DECISION DELEGATED TO DEVELOPMENT MANAGER

Application No: H17-0504-19 **Applicant:** Mr M & Mrs J Bennett
Proposal: Erection of dwelling - Outline approval H17-0242-17
Location: Off Stockhouse Lane Surfleet Spalding
Terminal Date: 9th September 2019

Job Title Proposed Dwelling Land adj. 23 Stockhouse Lane Surfleet, Spalding For Mr & Mrs Bennett	Date July 2019	Drawn by GG Checked by GE
Drawing Title Planning Drawing Site Plan and Location Plan	Job No. SE-1163 Dwg No. PP1000	Sheet Size A1 Revision 06

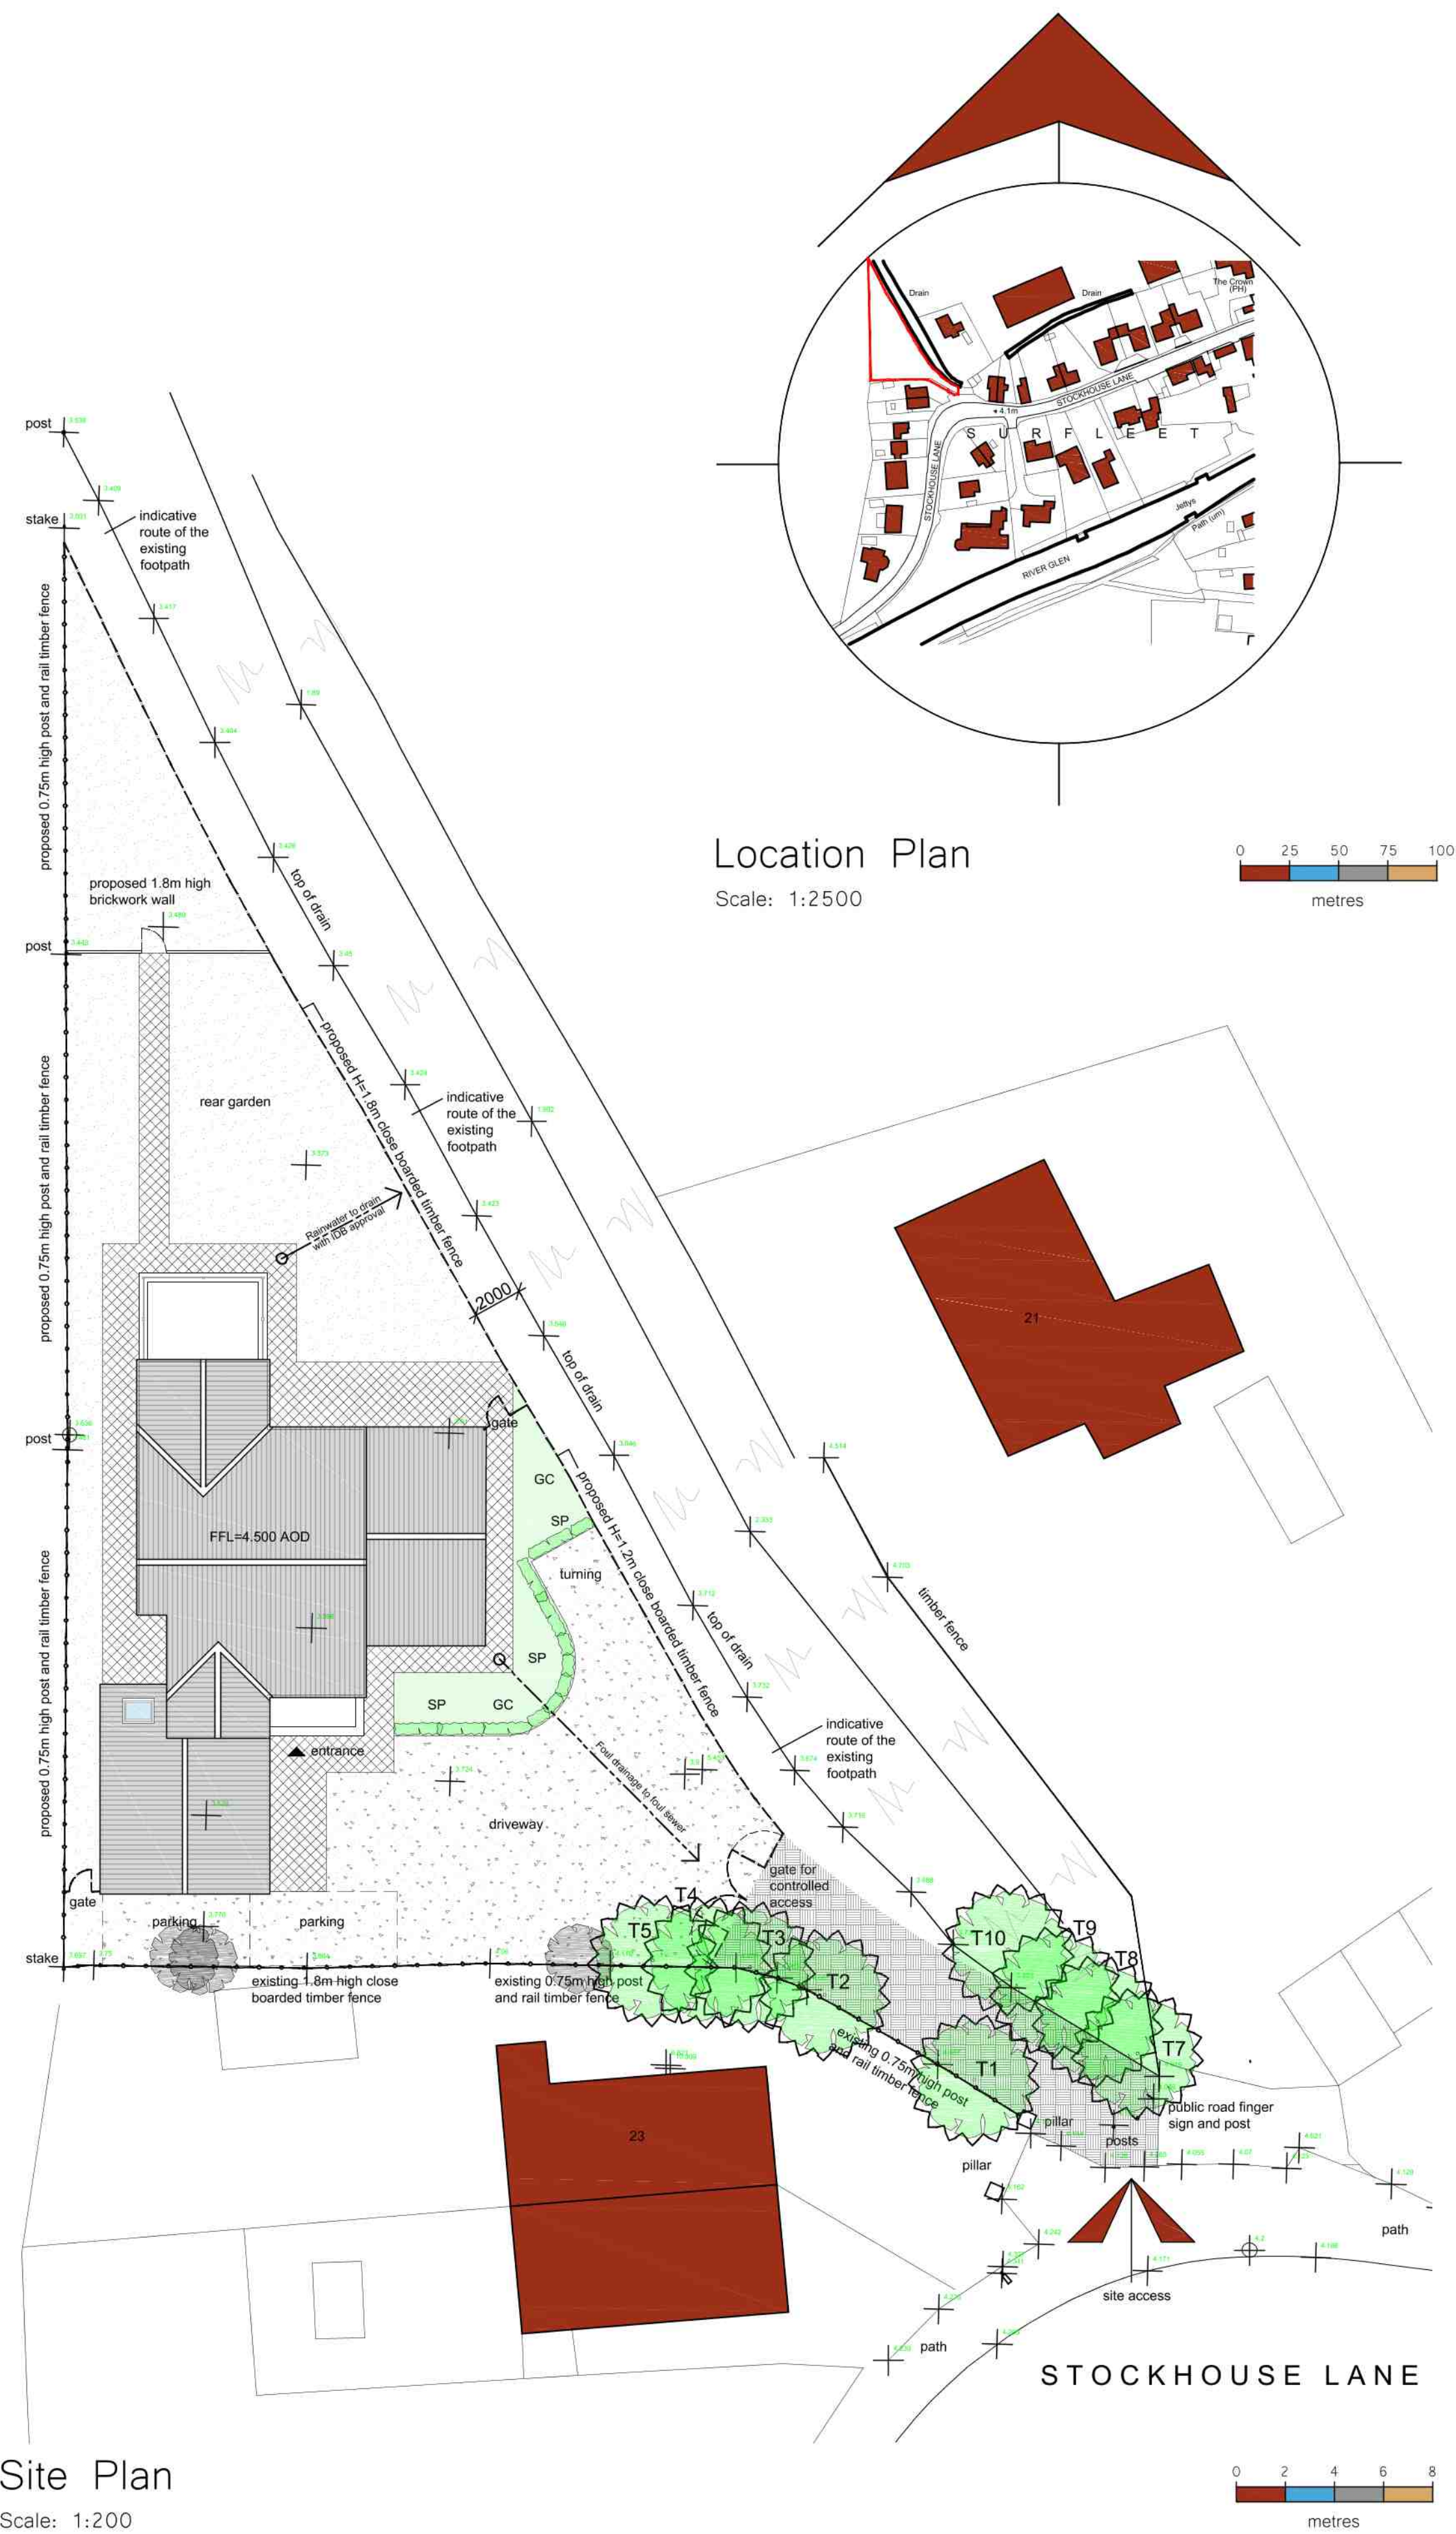
i/ It is expected that there will be no encroachment, either permanent or temporary, onto the right of way as a result of the proposal.

ii/ A minimum width of 2m should be retained to accommodate the public footpath. It is not desirable to install a fence between the drain and the public footpath as this will make the footpath feel enclosed.

iii/ No gates should be erected across the public footpath or gates posts erected at either side of the public footpath.

iv/ No surfacing works shall take place on the section of public footpath which runs along the driveway until a specification has been agreed with Lincolnshire County Council.

"Thank you for providing the amended site layout plan. The County Council Countryside Team has no further comments or observations to make in respect of the proposed development."

Following the submission of amended plans the Public Rights of Way Officer at Lincolnshire County Council is happy with the proposals.
